From: Kevin Eaton [REDACTED]
Sent: 17 May 2022 10:51
To: Kathryn Welch
Subject: Re: Flint Barn K/13/22/NMA
Attachments: scan_kevin.eaton_2022-05-17-10-45-21.pdf

From: Kathryn Welch <Kathryn.Welch@arun.gov.uk>
Sent: 13 May 2022 15:08
To: kev_eaton@hotmail.com [REDACTED]
Subject: Flint Barn K/13/22/NMA

01 PROPOSED GROUND FLOOR PLAN
Scale: 1:50

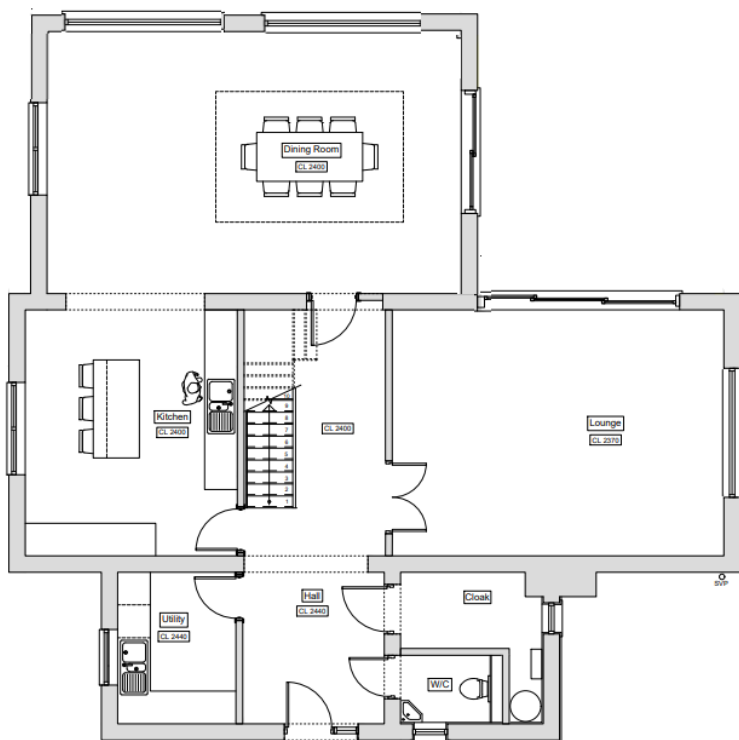
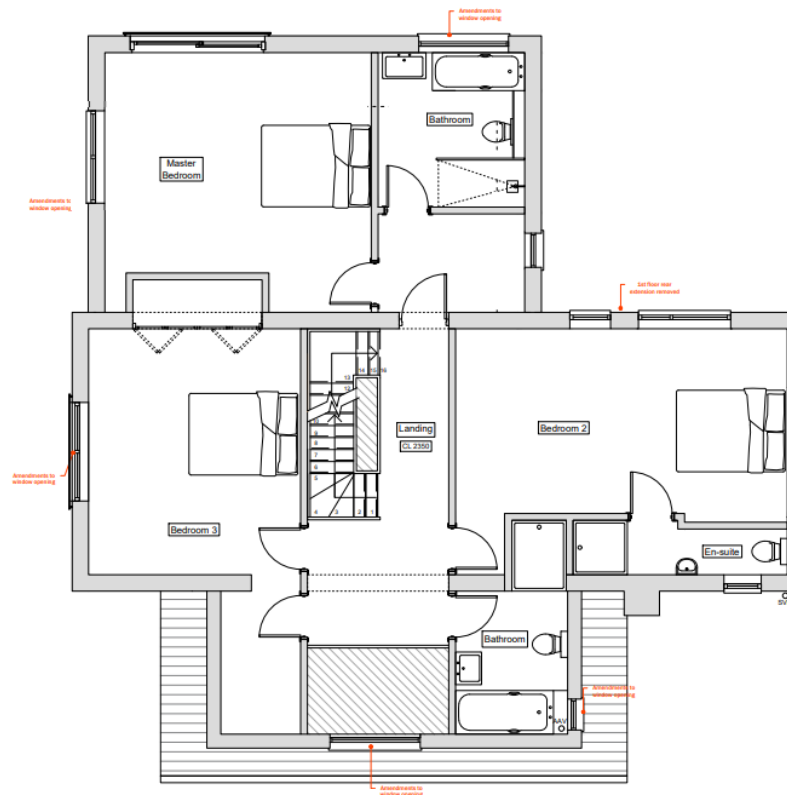
I'm just looking at signing off your NMA application however I note that the plans submitted aren't to any particular scale. Would it be possible to get a scaled version of the plans or can you annotate the measurements to the relevant bits of building to be altered.

Apologies for the delay in getting back to you but please note attached, which shows critical dimensions of the revised design.
